Your Ref: EN010151
Our Ref: 23/0471/NSIP
Contact: Sylvia Bland
Email: [REDACTED]@n-kesteven.gov.uk

RE: Beacon Fen Energy Park DCO – Deadline 7 Submissions for North Kesteven District Council

ExQ3 BIO3.2 – NKDC’s comments on the updated Ecology Chapter (REP5-013/014)

PART OF  SLR

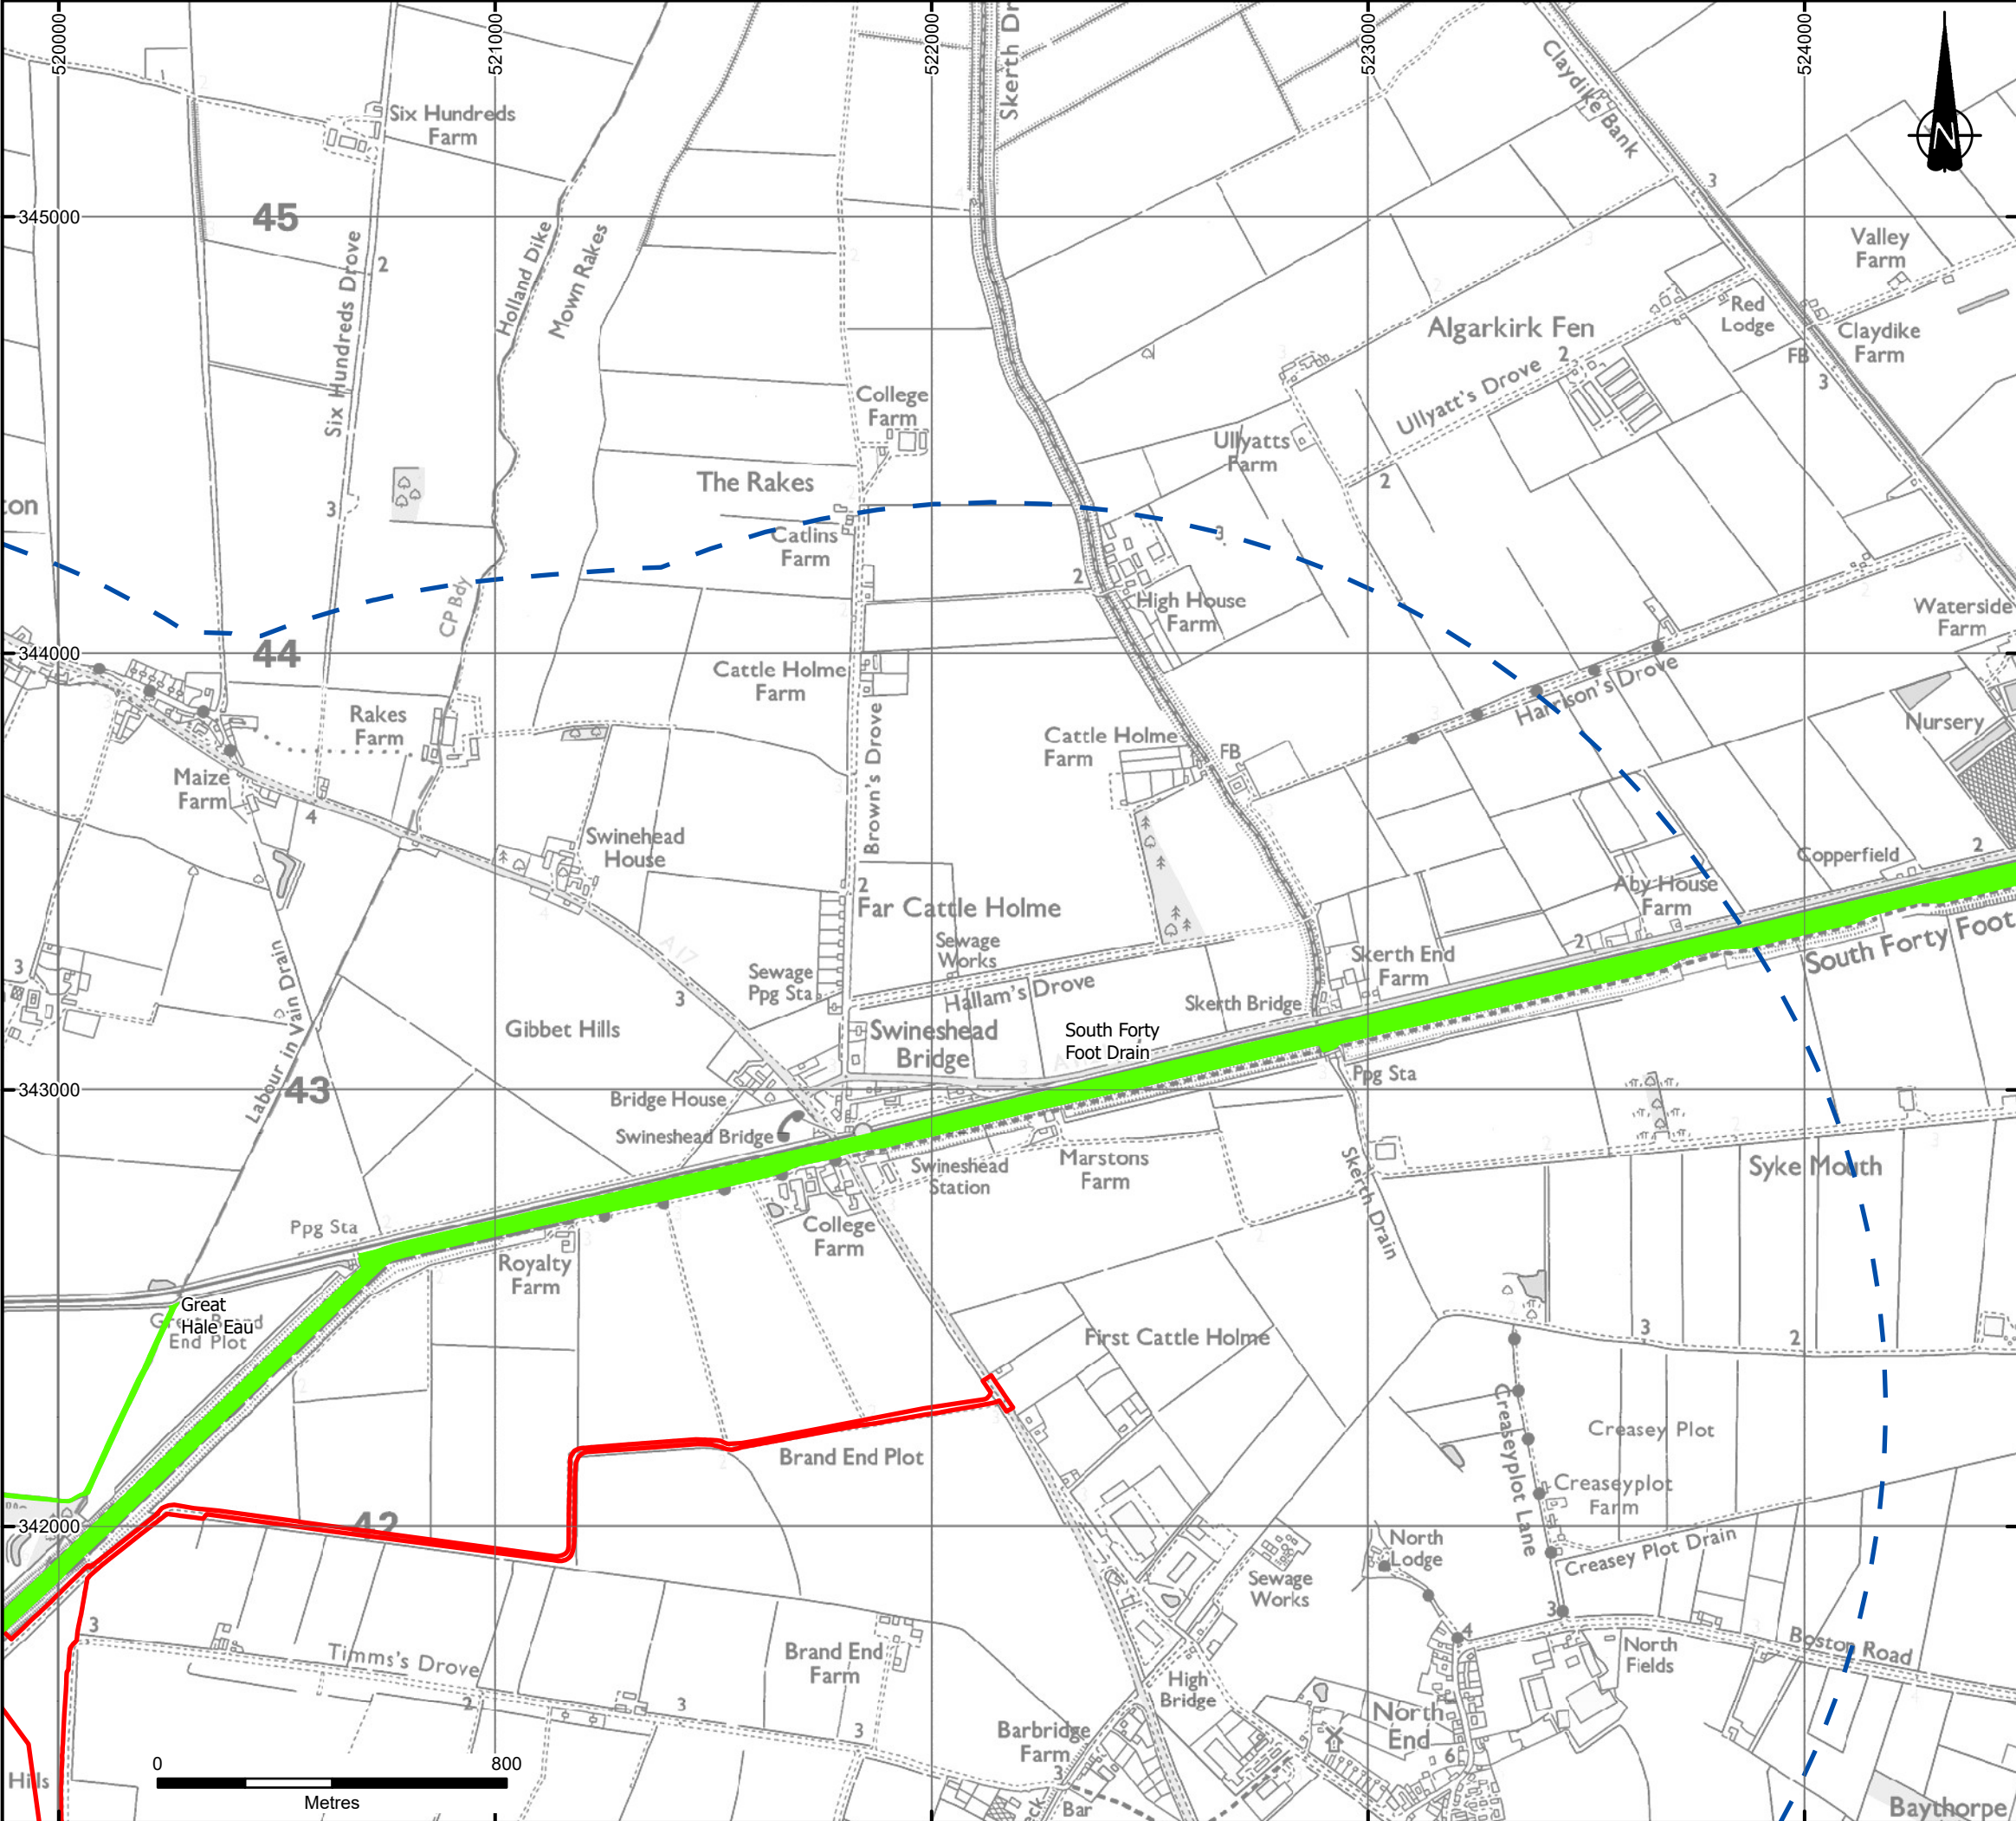
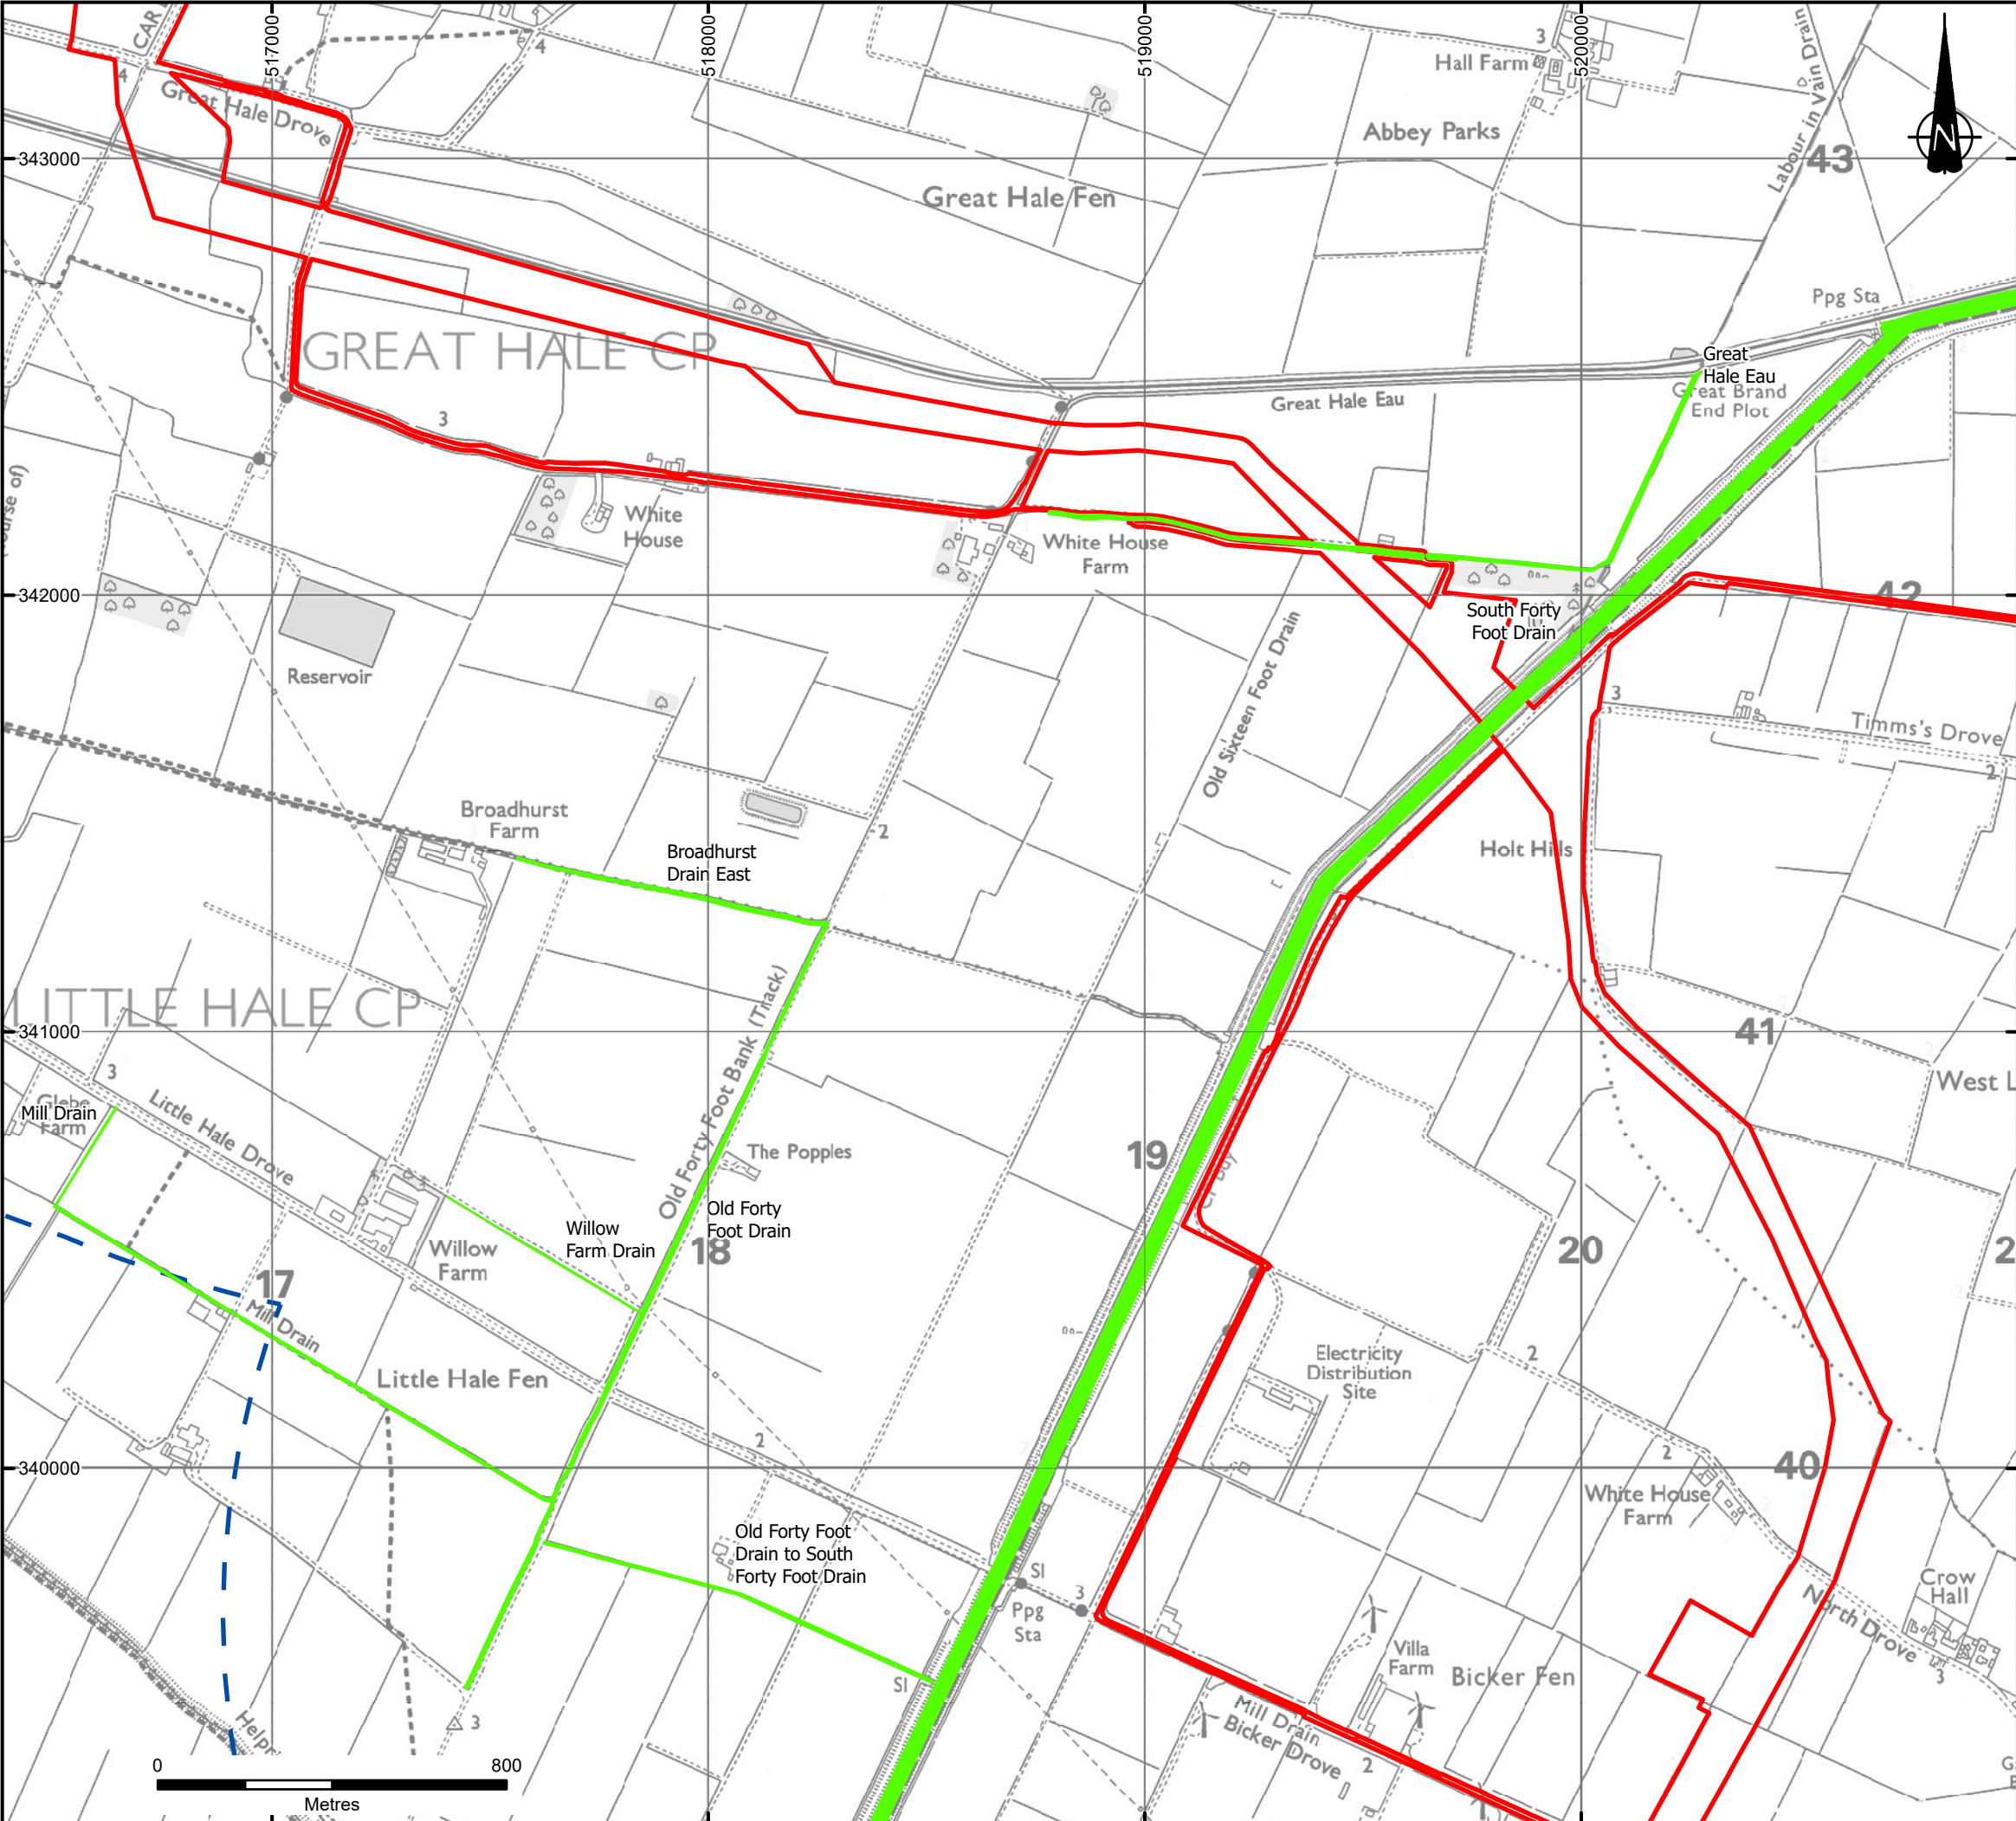
The impact on Great Hale Eau LWS seems to have been assessed without reference to specific baseline survey data (i.e. surveys relevant to the reasons for designation and aquatic habitats) and without a clear statement on the reasons for designation (this is not clearly identified elsewhere in the Chapter). There is also insufficient attention to whether this impact is avoidable, even though avoidance seems practicable (i.e. HDD, as committed elsewhere). Given this, there is an apparent conflict with Policy S60 of the Central Lincolnshire Local Plan.

This response overlooks the fact that a significant effect has been reported in relation to the Great Hale Eau LWS (paragraph 7.6.38 of REP5-014). It is irrelevant that the impact is subsequently mitigated to an acceptable level given the mitigation hierarchy needs to be addressed, as identified above, and this requires avoidance to be considered first.

- A new impact is identified in relation to Great Hale Eau LWS. As noted and discussed above, the applicant does not demonstrate a mitigation approach that responds to Policy S60 of the Central Lincolnshire Local Plan. It is not agreed that the mitigation hierarchy has been adequately applied. There are methods available to the Applicant that would avoid the impact (HDD or similar) and that are committed elsewhere for other watercourse crossings. The mitigation offered in Table 7.9 of REP5-013/014 focusses on restoration of bank habitats, but it is not clear this mitigation adequately responds to the reasons for designation as these are not clearly stated within REP5-013/014.
